June 3, 2021

Re: Responses to the following comments, EA Number EA1881, File Number AL2014:

Regulatory Permits Management, Inc.  
Consultant to Ellicott Sand and Gravel

Figure 1 - Bank Protection Plan cross section (Revised 10-30-19)

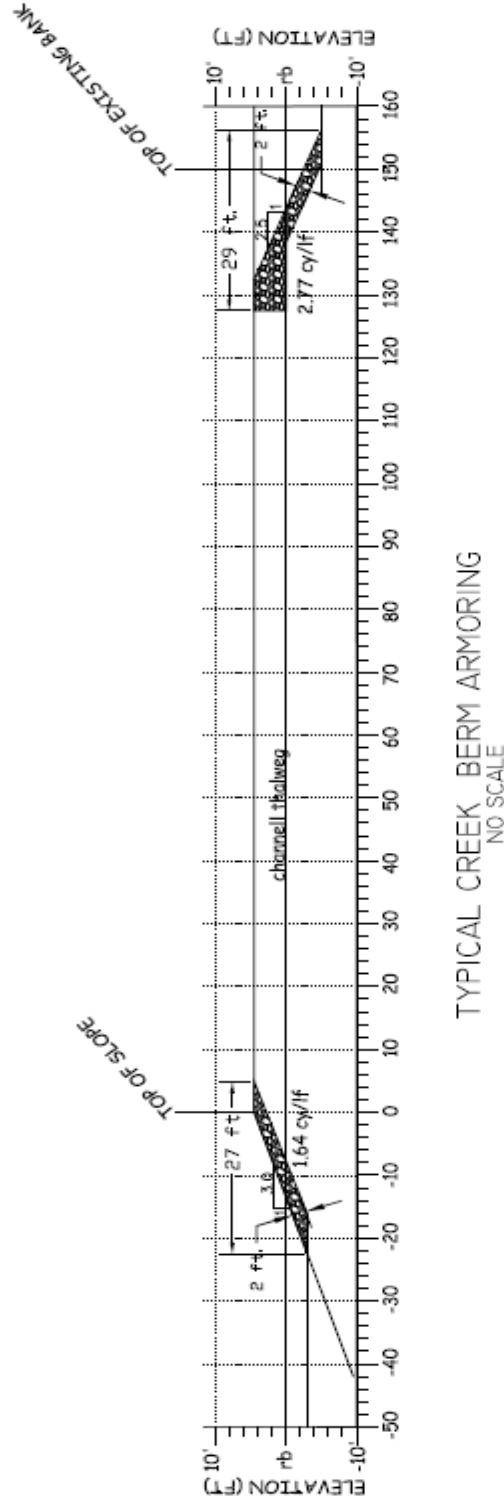
*“Since a majority of the property is developed agricultural land, CPW comments will address potential impacts to Black Squirrel Creek... Within the Squirrel Creek Drainage, there are populations of Arkansas Carter ... downstream of that location. There should be minimal impacts to any riparian areas or stream beds, both during construction and after, and any stream bed should be handled as a stream crossing whether or not water is present at the time of construction. Minimize impact to these streams is a priority for CPW and avoidance is best whenever possible.”*

- Comment:  
*“CPW recommends a ground disturbance buffer with minimal activities or operations within 300 feet of any lake, reservoir, wetland or stream.”*
- Response:  
As stated above, we will maintain a 150-foot setback from both creeks. In addition, as stated above, we will armor the inner and outer banks to control bank erosion during storm events.

- ✓ In our September 9, 2019 response to the DRMS adequacy comments, we stated, “There is no way to totally avoid a stream capture during a 100-year event. We have reached a conclusion that we need to increase the width of the setback in each stage and armor the inner and outer banks using the Urban Drainage Guidelines. This is intended to prevent a change to the ordinary flow channel and keep normal flows to the excavated areas and yet still allow for flood relief.”

- ❖ We proposed and the DRMS approved our increase of the berm separating the pit areas from the creeks from 50 feet to 150 feet.
  - ❖ Based on our conversations with the Corps. of Engineers, the above proposed armoring activities will be outside the Ordinary High Water (OHW) line and therefore outside the jurisdiction Corps. and armoring can be constructed without a 404 permit.

- ✓ We submitted the plan for armoring the inside and outside banks of the areas along Black Squirrel Creek to DRMS, dated August 26, 2019 which was approved as part of the DRMS/MLRB permit application for the Schubert Ranch Resources Sand Pit.
